- 1 - Sidewalk and Curb cut / David Margolis-Pineo
Wednesday, November 25, 2009 8:32:13 AM

GRADING AND UTILITY PLAN
 OF:
 231 YORK STREET
 PORTLAND, MAINE
 FOR:
 DANA FISHER, LLC
 PORTLAND, MAINE 04112

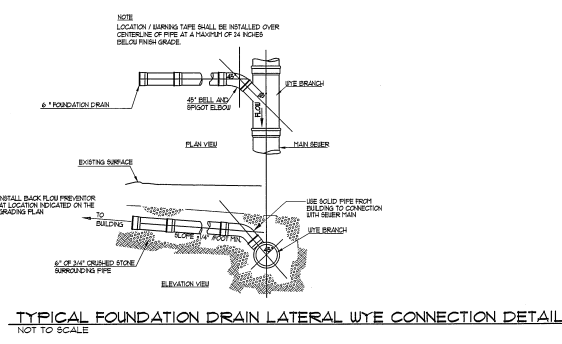
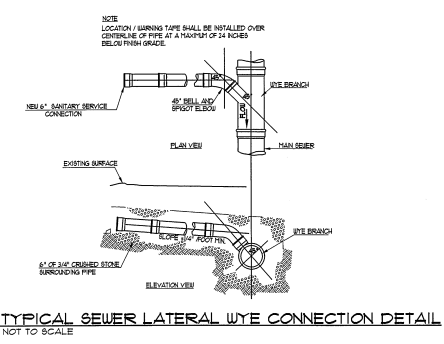
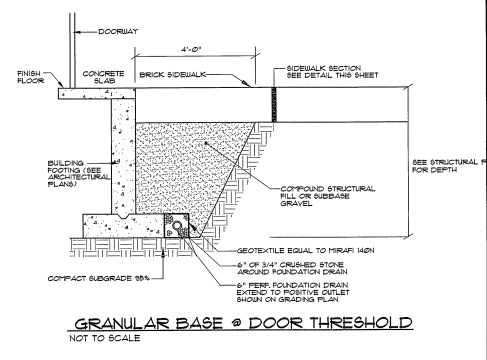
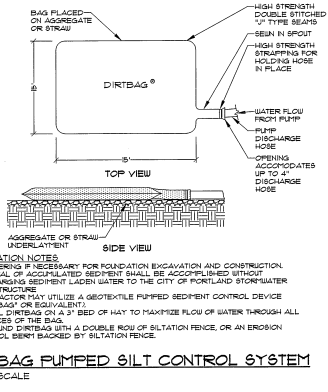
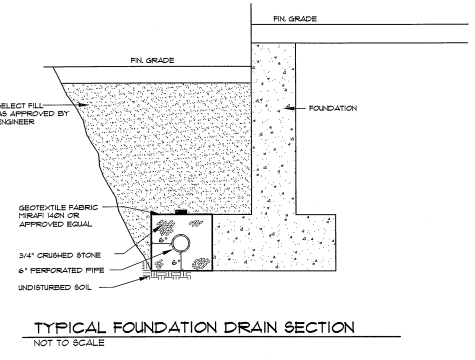
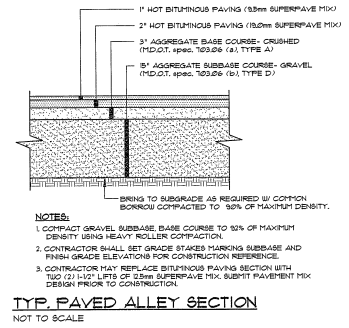
The applicant is asked to evaluate an alternative to discharging the proposed foundation drain to the City's sanitary sewer. Is it possible to discharge to catch basin where future stormwater separation would remove this water from the sanitary system?

Since the proposed sanitary sewer connection into York Street will connect to a combined sewer system, the applicant is advised to install a backflow preventer on the sewer lateral.

The existing water and gas service on Brackett Street are not shown on the utility plan. Will they be reused or abandoned.

It is the City's desire to inspect the granite vault on the corner of Brackett and York Streets. If the structure is in a failure condition, the City will coordinate with the applicant.

TYPICAL DUMPSTER GATE
NOT TO SCALE

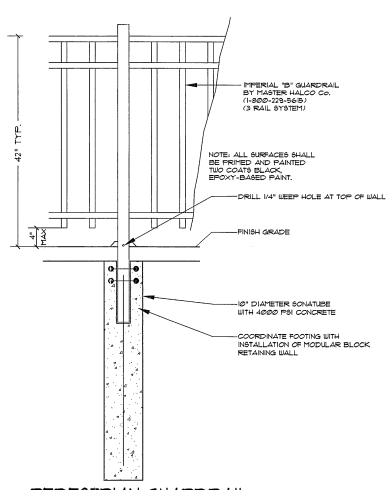
Plans indicate chain link fencing on this plan; wood panelled fencing on elev. and there is a detail for dumpster enclosure that shows curved wood gates. Gates at access and interior enclosures should be high quality material and screen the dumpsters and paved access area. City Arborist may have additional comments.
